Application No: K/17/22/PL
Site Address: Panorama Golden Acre Kingston BN16 1QP
Description of works: Conversion of existing 2 No flats into 1 No dwelling, single-storey extension with a sloping roof, new porch on ground floor, conservatory at first floor and roof extension, replacement of existing windows, doors and roof tiles. This site is in CIL Zone 4 and is CIL Liable as new dwelling.

Thank you for your internet representation made on 28th July 2022 which has been recorded as an objection with the comments as follows:

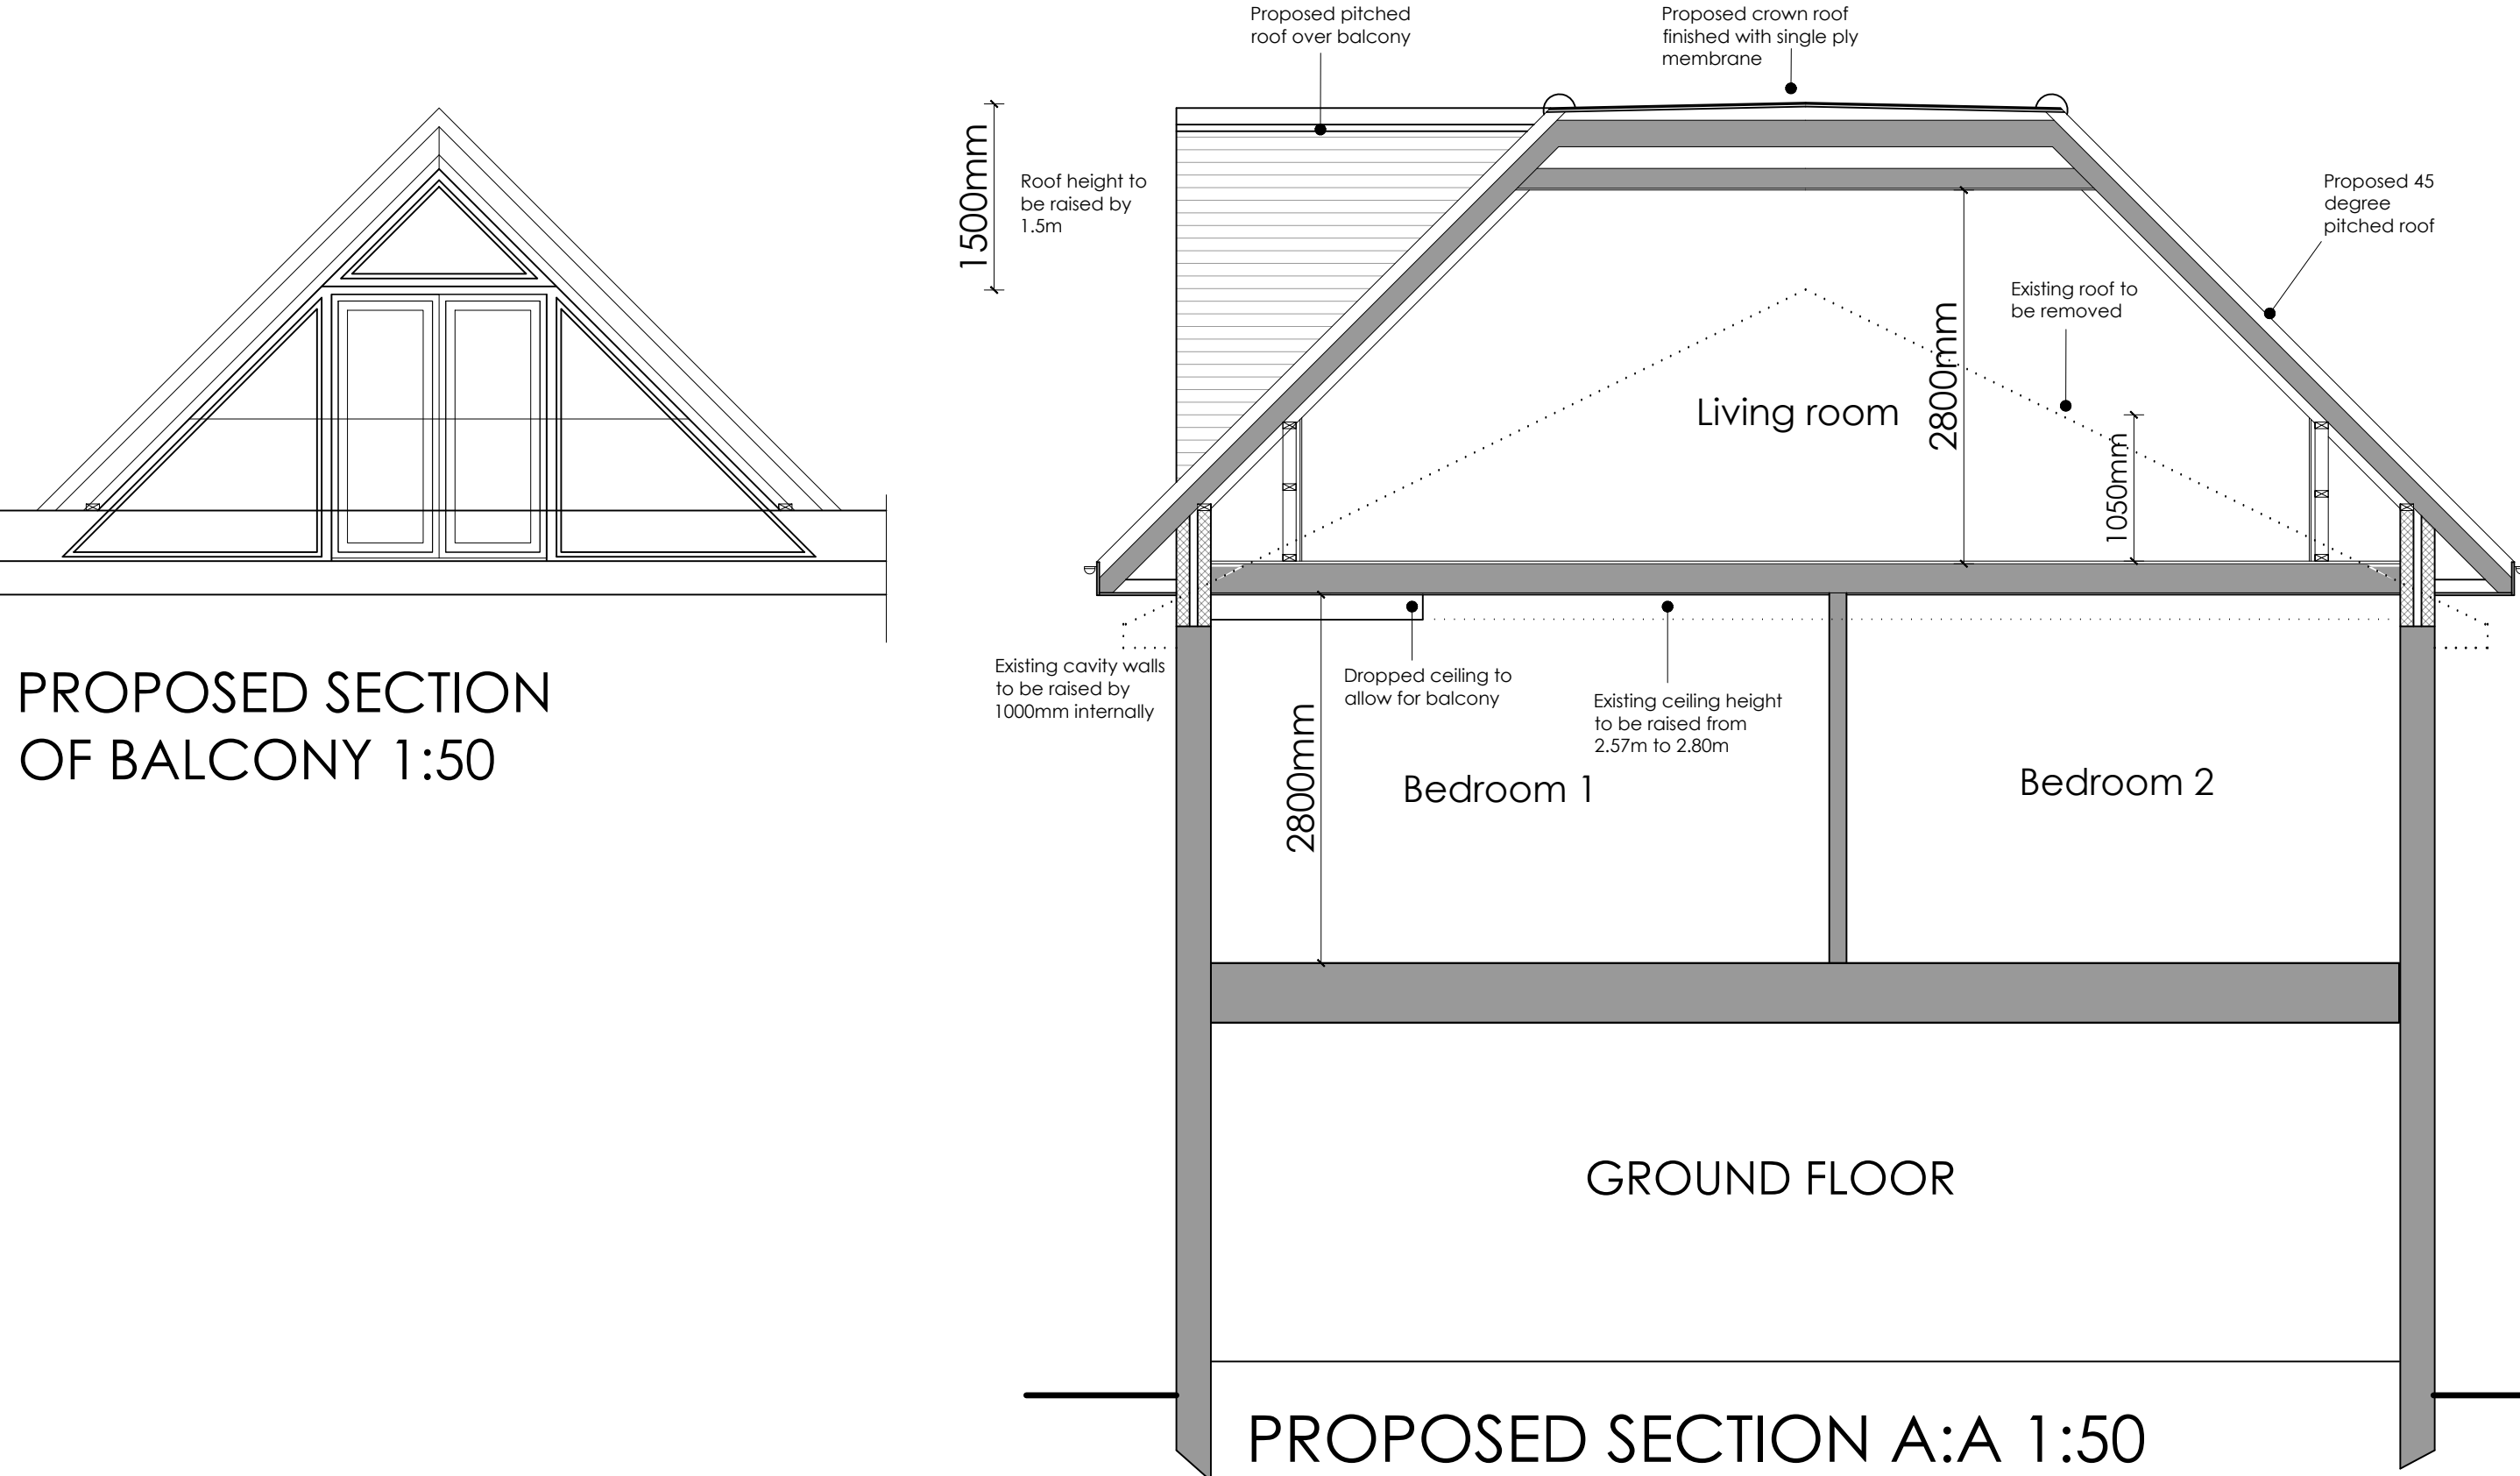
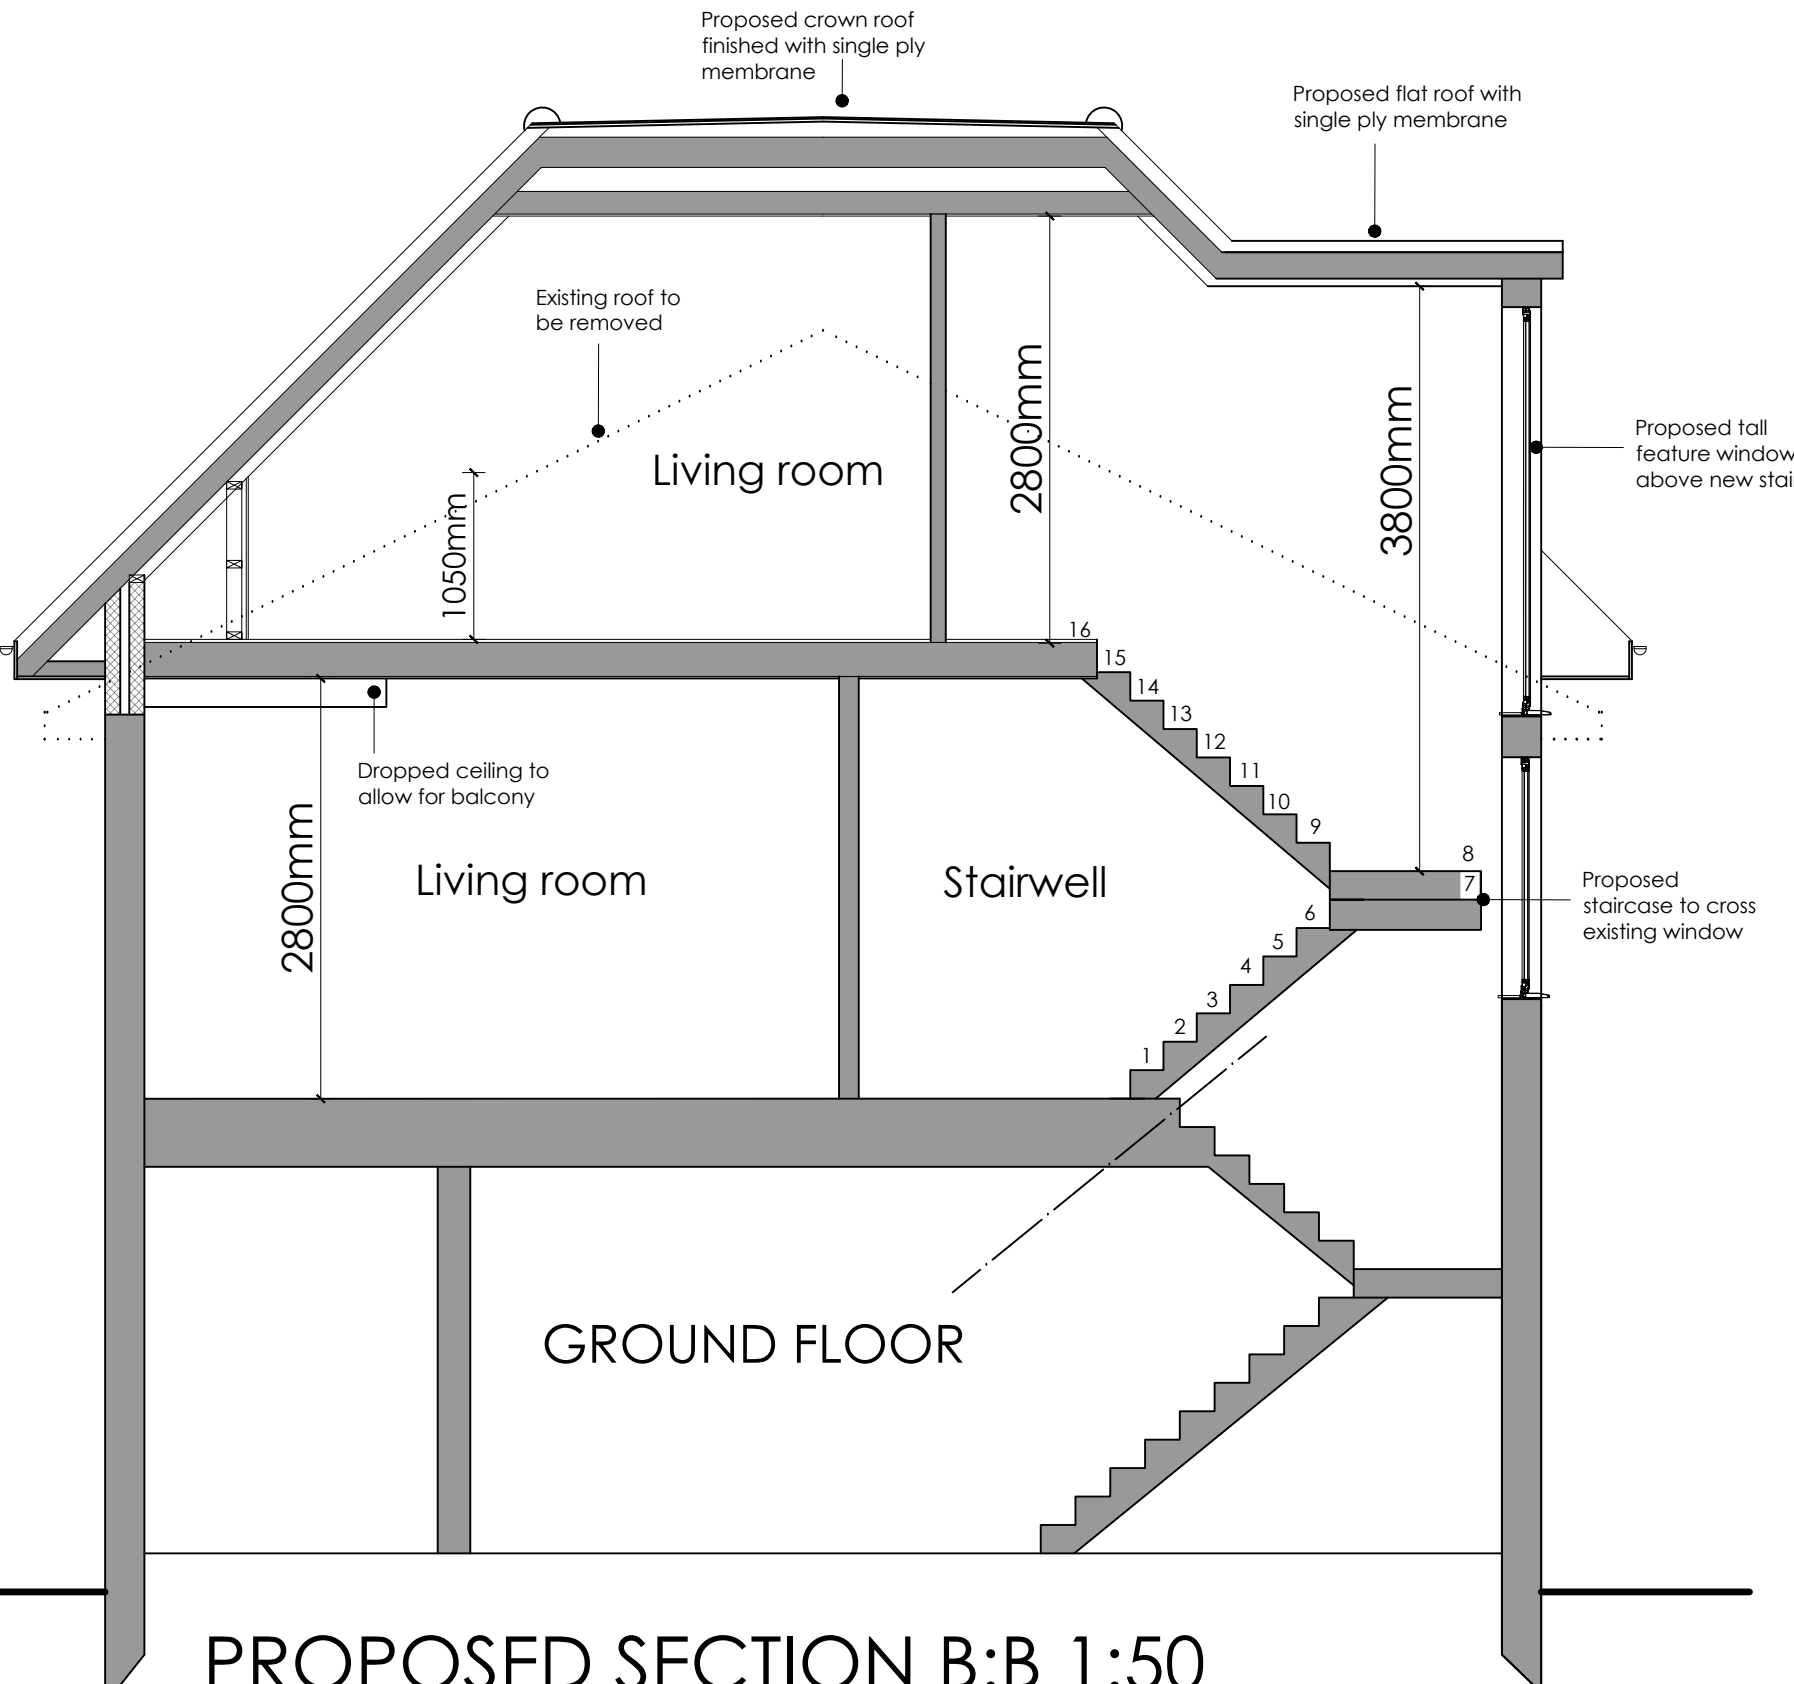
2. There needs to be an understanding of the impact the additionality of this development will have upon us. With the enlargement of the roof space and raised ridge height and the inclusion of both the east elevation and north elevation windows within the roof to create the second floor will lessen our privacy even further. The northerly elevation roof window will look directly down into our main bedroom that is on the south west corner of our property, let alone the eastern elevation roof windows that will expose the totally of our rear garden with

no opportunity of screening at that height. The enlarged windows will allow increased opportunity for observations by the occupants of Panorama to not only the Greensward but the entire southern aspect and into the rooms of our property.
